Town & Country Planning (Control of Advertisement) (England) Regulations 2007 (as amended)

Various non-illuminated & internally illuminated signage
Former LEC Site Shripney Way Bognor Regis

Thank you for your internet representation made on 9th January 2013 which has been recorded as '**an objection**' with the comments as follows:

Building Sky
Signage Details

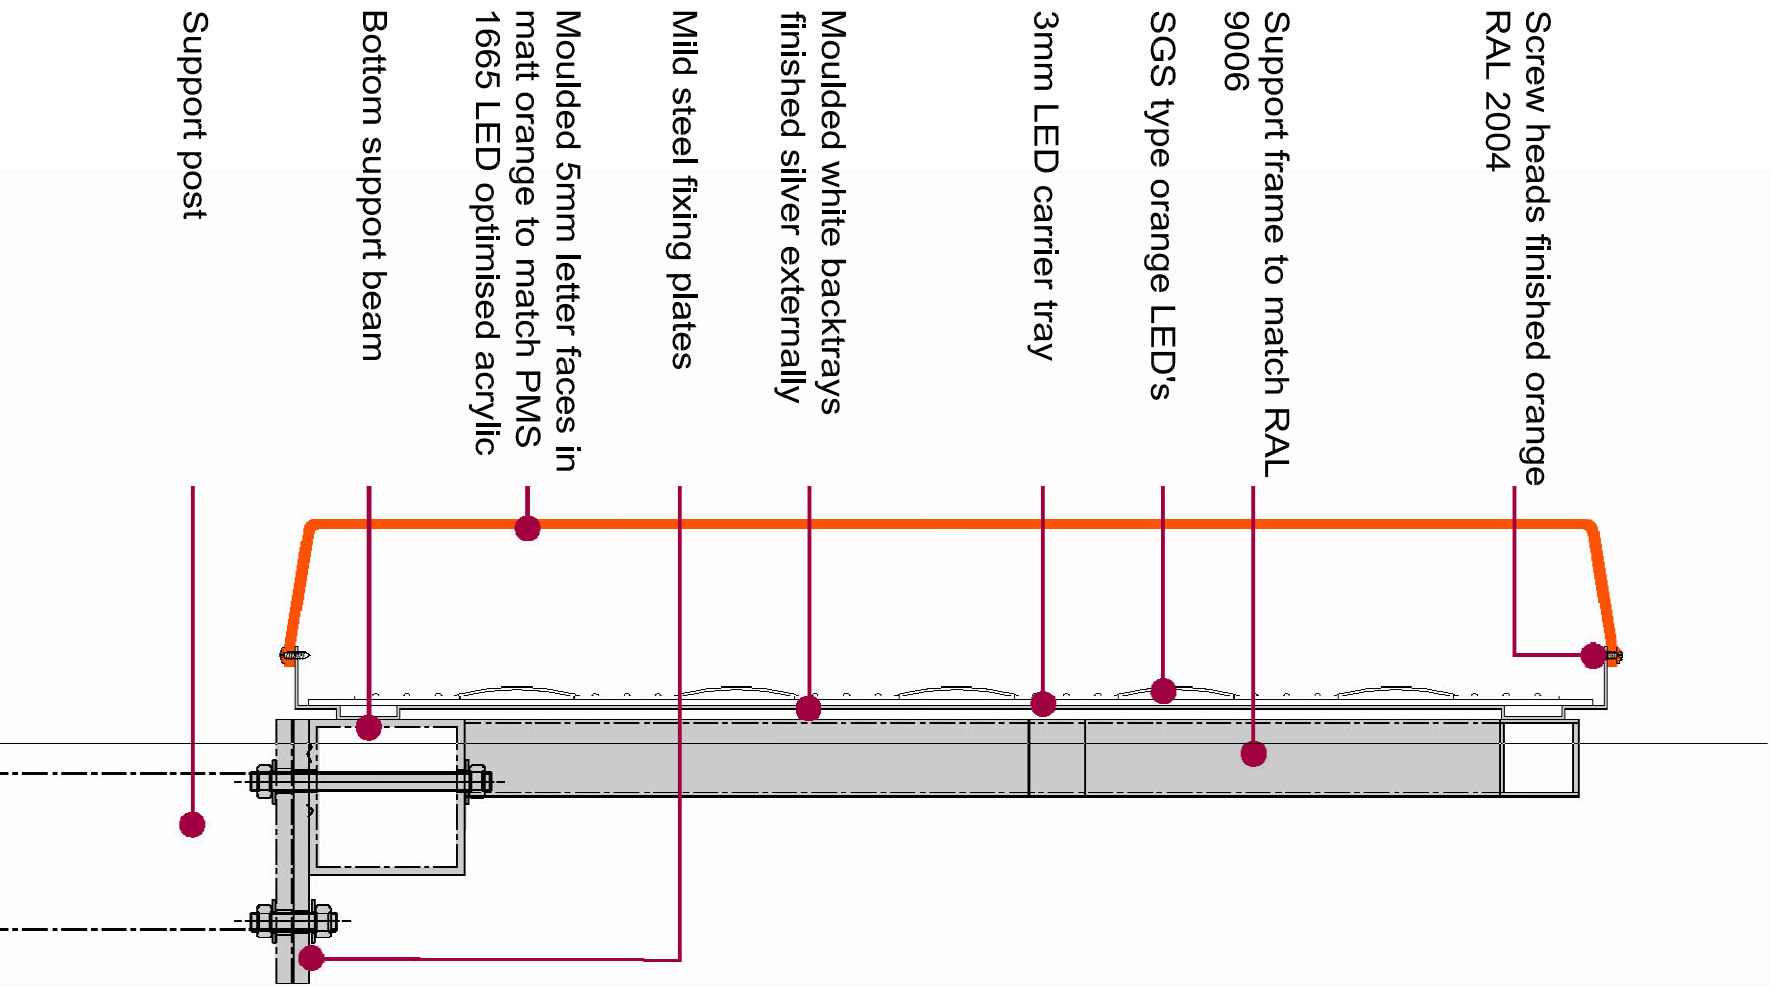
I understand that this application is coming before Development Control next week. When comments were originally solicited, I wasn't a Parish Councillor at Bersted and, as an individual, would not have foreseen the impact of the 2 large illuminated signs which have been placed on the roof. I was amazed to see how visible they are from the Arun Leisure Centre for example. I do feel that they are too prominent in their current position and probably have to be so large because they are so high. The end result are incredibly bright signs beaming out which detracts from the attractive design of the building as well. My main problem, however, is that, should permission for these be granted, other stores and outlets along this road will surely want the same for themselves which can only surely bring about a 'Las Vegas' or strip mall effect to one of the key arterial routes into Bognor Regis to the detriment of us all.
